Planning Services Sign Permit Review Form

Date of Submittal	Application Number	Applicant	Landowner
02-25-19	SIGN1902-0002	Sign + Awning Systems	33418 Egypt Crossing LLC
Contact Person	Rachel Taylor	Contact Number	910-892-5900
Sign Location	2624 NC 24-87	PIN Number	9594-24-2391

HWY 55 BURGERS

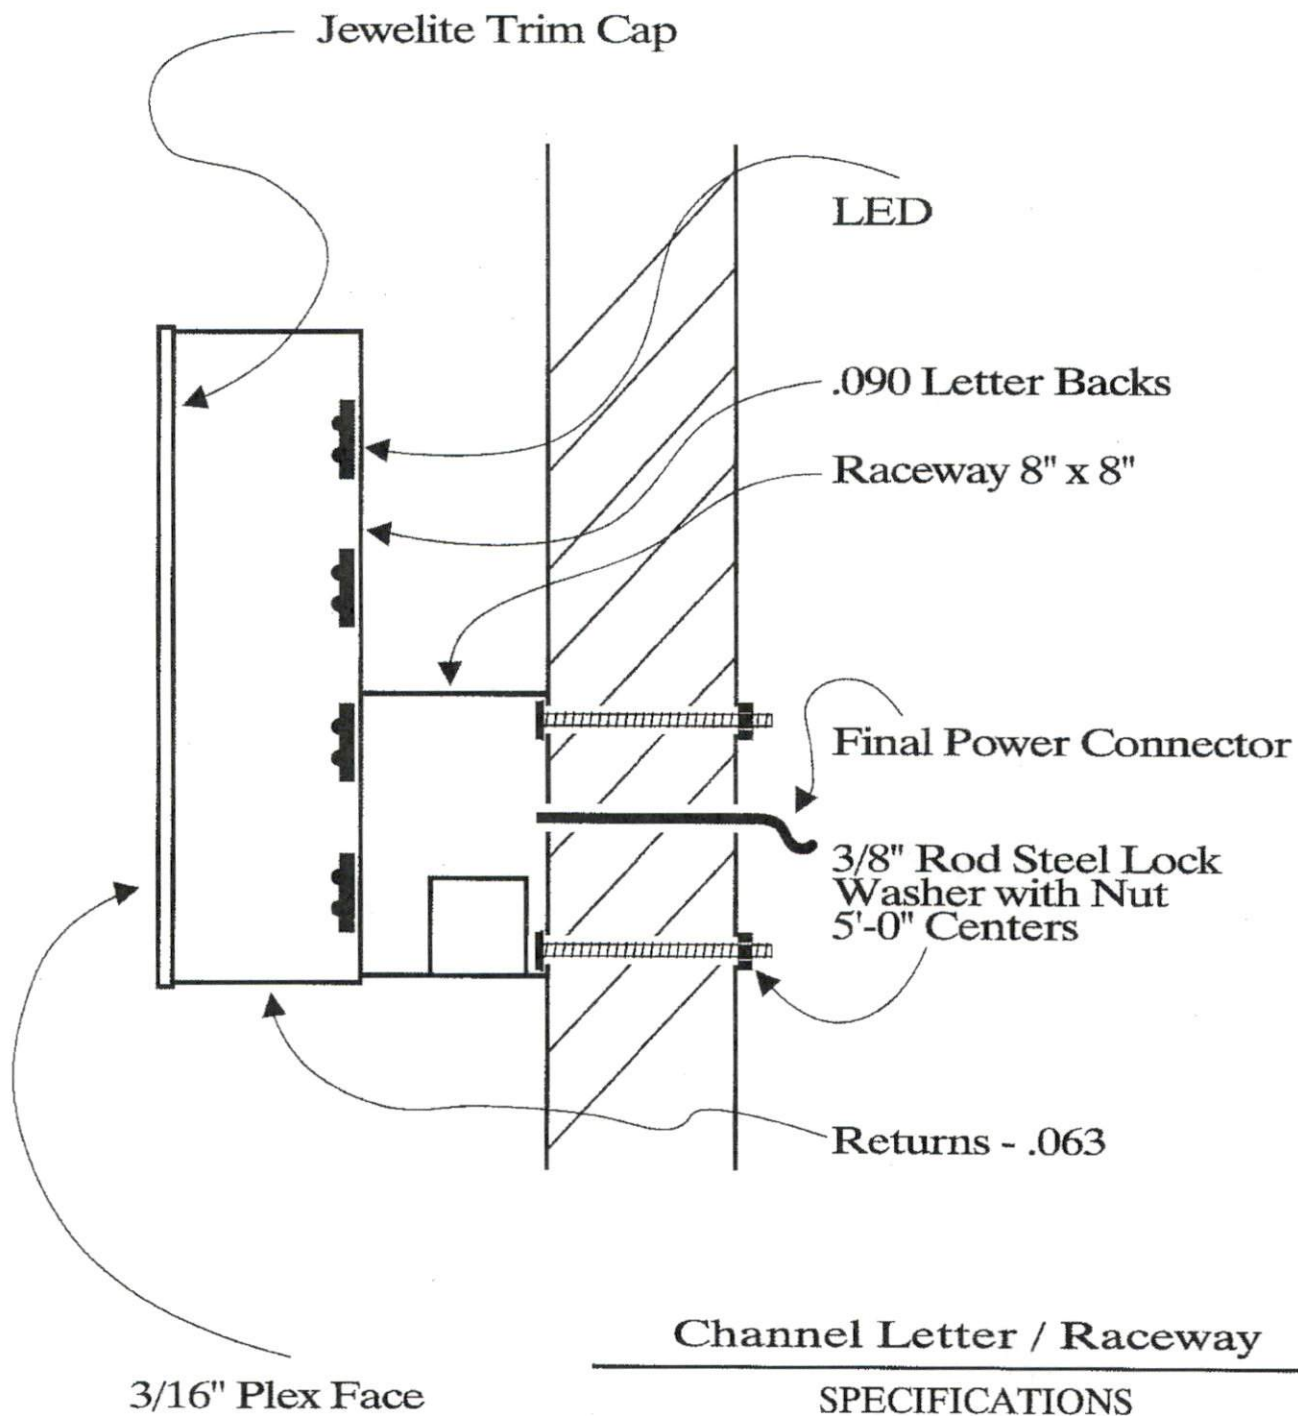
Wall sign:
 102" x 49.5"
 = 8.5' x 4.125'
 = 35.0625 sq. ft = OK ✓
